From: Cruse & Associates <cruseandassoc@kvalley.com>
Sent: Wednesday, February 14, 2018 9:00 AM
To: Chelsea Benner
Cc: Ron Mitchell; Sonja Mitchell
Subject: Re: SP-17-00003

I just wanted to follow up on your 1/31/2018 letter to clarify some of the comments received. DOE's comment requiring a group B water system has never been required to my knowledge for 20 acre parcels. We understand it will fall under a single water right and need to be mitigated but I have been allowed individual wells on all applications to date. Group B water systems are usually not feasible in the 20 acre zones as the homes can be 1000's of feet apart. Can you please forward whatever code requires a group B system for us to review?

### NANEUM ROAD SHORT PLAT

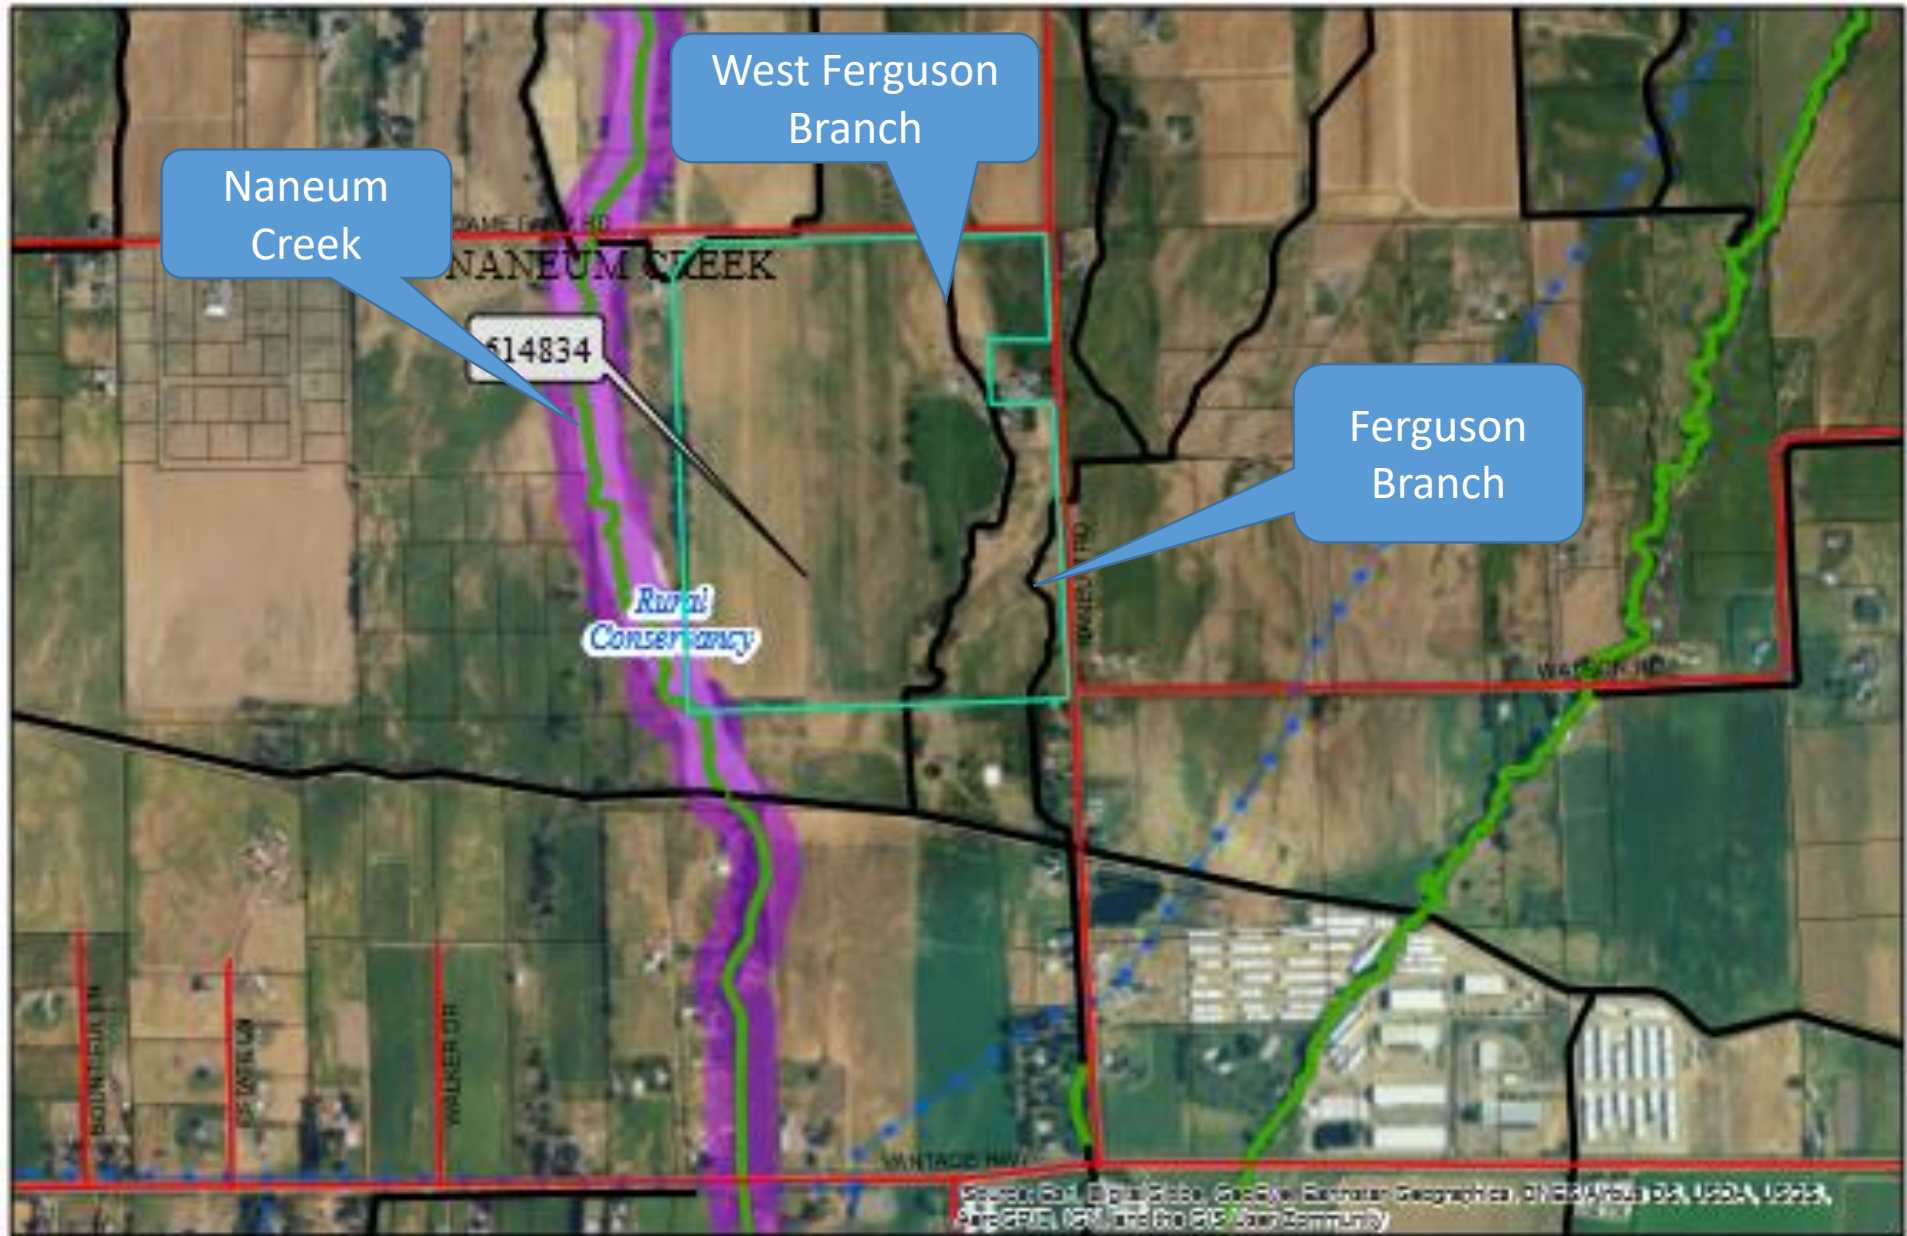
The comments received for main Nanuem creek appear to be correct as it is classified as a shoreline of the state and designated in the rural conservancy. I do not know if this property is within 100' of Naneum Creek as the creek is outside of this ownership but can add a note that shoreline restriction from Naneum Creek may affect the SW corner of Parcel 1A and to contact Kittitas County for additional information. The Ferguson Irrigation Ditch (Ferguson west branch per wdfw) is a man made ditch to convey irrigation water to properties to the south. Ferguson Irrigation Ditch does go dry and collects KRD irrigation runoff to flow throughout the dry season. This ditch is unclassified by WA DNR and not a shoreline of the state. The ditch that crosses under Naneum road and runs through Lot 1C (Ferguson branch per wdfw) is unclassified by WA DNR and not a shoreline of the state. The area along this ditch is not a desirable location to build and intentionally placed the 60' access easement north of the Naneum Road crossing to not have to cross this area.

The intended buildable area of Lot 1C is to be NW of the Ferguson Irrigation ditch in the existing hay field. The landowner has owned this land for more than 30 years, and this area encompassing Lot 1C has been used continuously as productive farm and pastureland. Lots 1A and 1B have numerous building areas within their parcel boundaries. The existing home and barns adjacent to Ferguson Irrigation Ditch have been there for decades and have not had problems. Approving this short plat in no way circumvents any rules or regulations as all future construction permits for these parcels within this short plat are required to go through a review process with Kittitas County. This will ensure all codes are met for whatever structure or development are proposed wherever it is located in the parcel. Please contact us back with any questions or concerns and would be happy to schedule a meeting to discuss how best to proceed.
